CITY OF ALBUQUERQUE

March 22, 2013

Re: Cheddar's Casual Cafe
Engineer's Stamp date 3-6-13 (F17/D006)

2 of 6

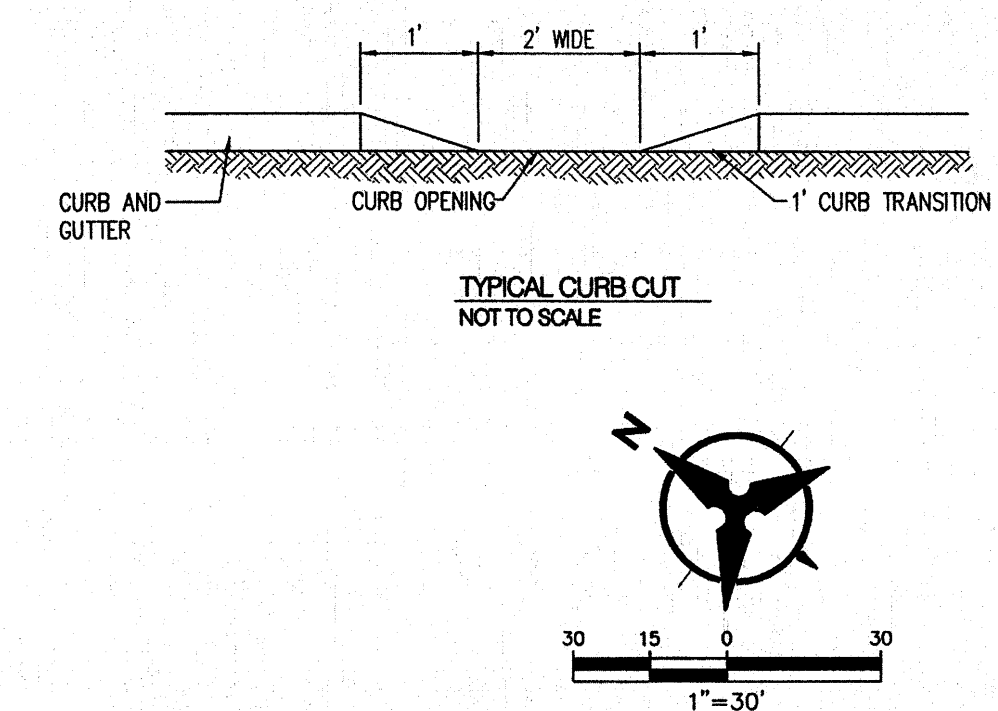
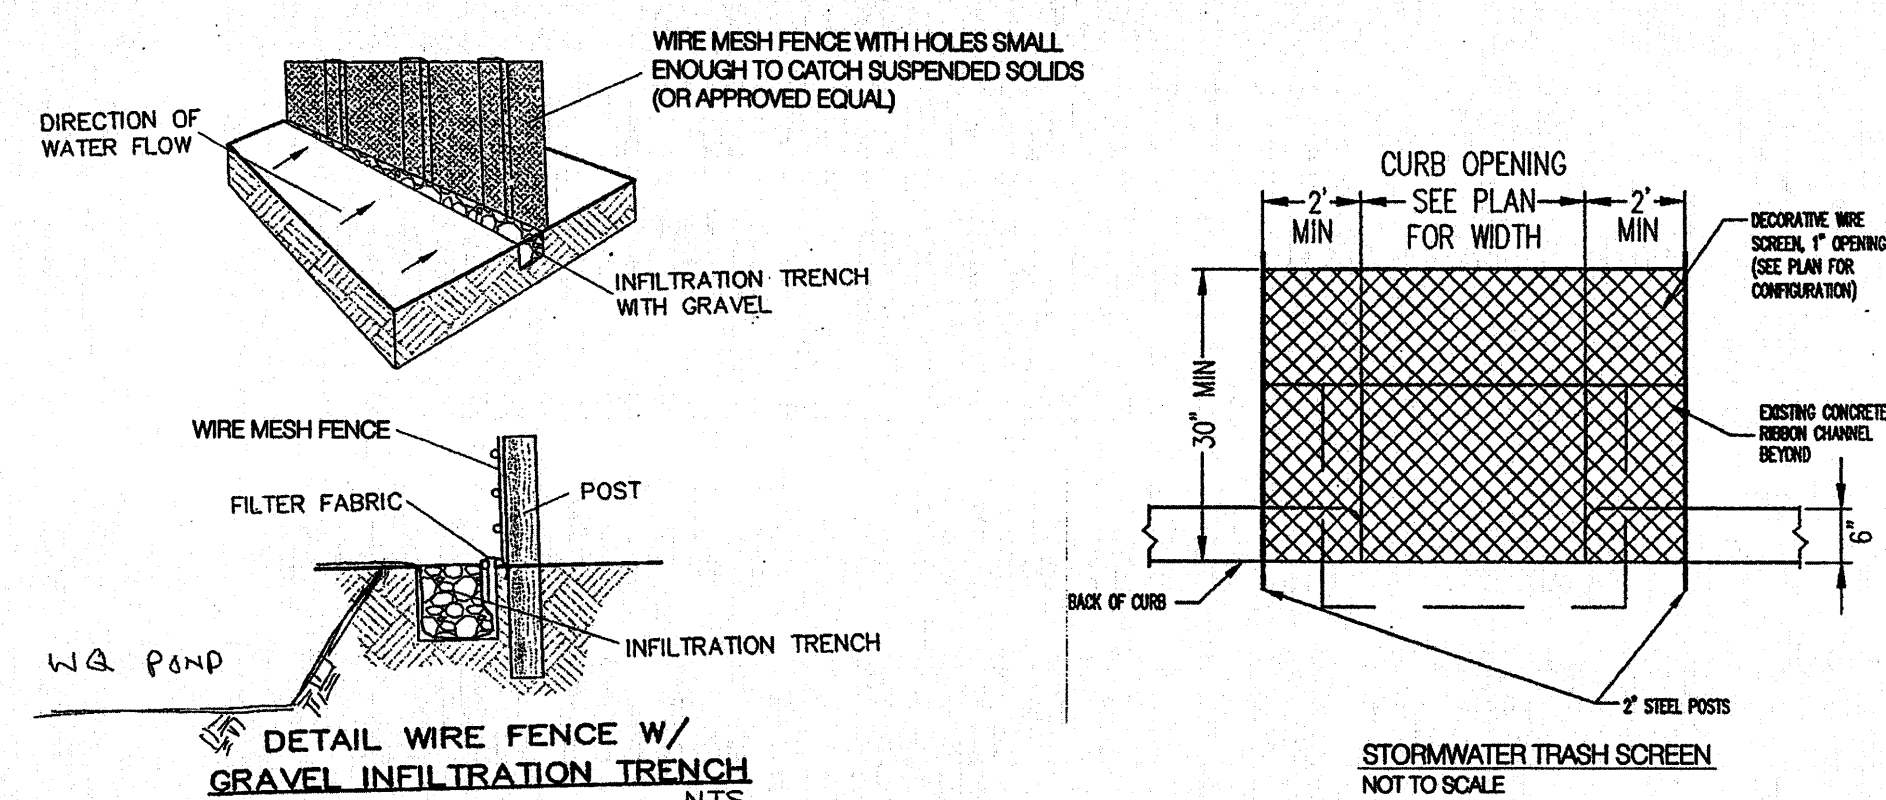
3. It does not appear the water quality/desiltation pond will function as proposed unless the wire mesh is to be built on the edges of the inlet for the following reasons:

- a. The wire mesh fence will restrict flows and create a pond upstream of the inlet/water quality pond location. If the wire mesh is to be built around the inlet, it should be shown this way on Sheet 2 of 6 as well as on the detail on Sheet 1 of 6.

- b. Provide justification/specification sheet that the wire mesh will be able to pass 11 cfs.
4. It appears the outlet pipe is oversized as the capacity is shown to be 54 cfs, and the flows appear to be restricted to 11 cfs by the provided Weir equation. It is acceptable to oversize this pipe.

5. It is not clear where the 0.45 of head comes from? Provide calculations.
6. Provide a WSE on the grading plan for the water quality pond.
7. Add a note or show grades for the landscape areas/parking islands so they will water harvest in locations further than 10 feet from the building.
